From: Jack Spees [REDACTED]
Sent: 30 June 2025 15:10
To: Planning
Subject: Application 3/2025/0357
Attachments: 1200-D001A(P2).pdf; 1200-D002A(P2).pdf; 1200-D026(P2).pdf; Access Route - Showing Proposed Passing Place views.pdf; BNG Exemption Passing Places.pdf

With regard the comments from LCC Highways please find the below.

Client RIBBLE RIVERS TRUST	Scale NOTED Date JUNE 25 Drawn WS	Drawing title ACCESS DETAILS
Job title ALTERATIONS HORROCKSFORD FARM HOUSE	<b>1200 D026</b>

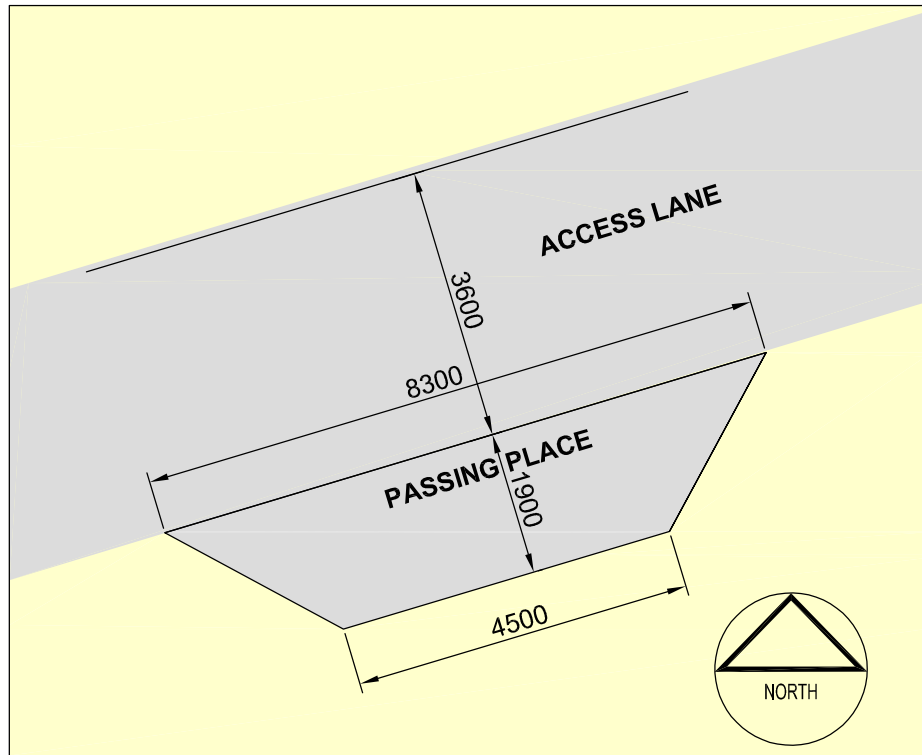
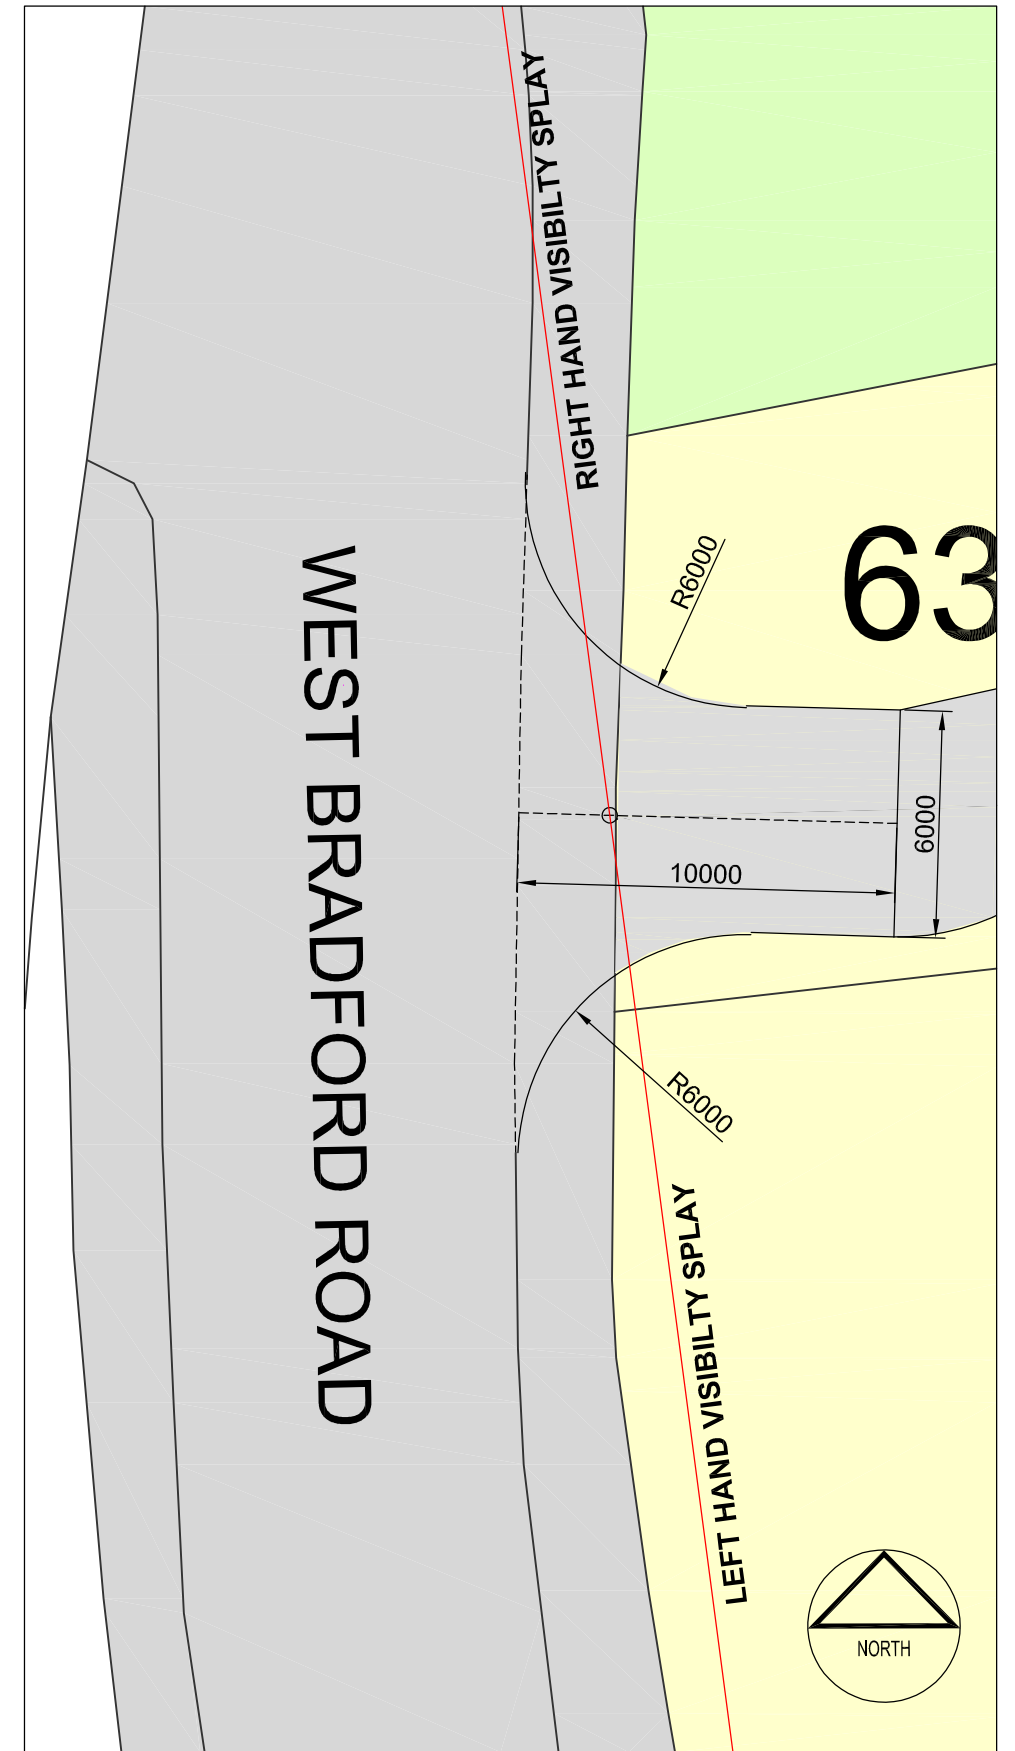
Request to increase the road width. As a conservation charity we are keen to reduce our environmental impact and feel that this request is unnecessary given our levels of activity, and conflict with our Charitable objectives. It will also reduce our income significantly (grazier rent, and agri-environment schemes) from the grassland, which would impact on the viability of the wider plans. However, we acknowledge that we need to make some adjustment to enable vehicles to pass, and keep the main highway clear. As such we have undertaken a site visit to identify locations that would be suitable for 2 passing places. Please find attached photos and drawing 1200-D001A(P2) and D026(P2).

D026(P2) also details the entrance to the access road from the main carriage way, which includes the site lines which are in compliance with the site line requirement as per table 7.1 from Manual for Streets and the traffic speed of 30mph which is the identified speed limit at this location. We will also complete the recommendations identified on the existent enacted planning application, that have not yet been completed ((e.g. movement of the hedges and fences to improve site lines).
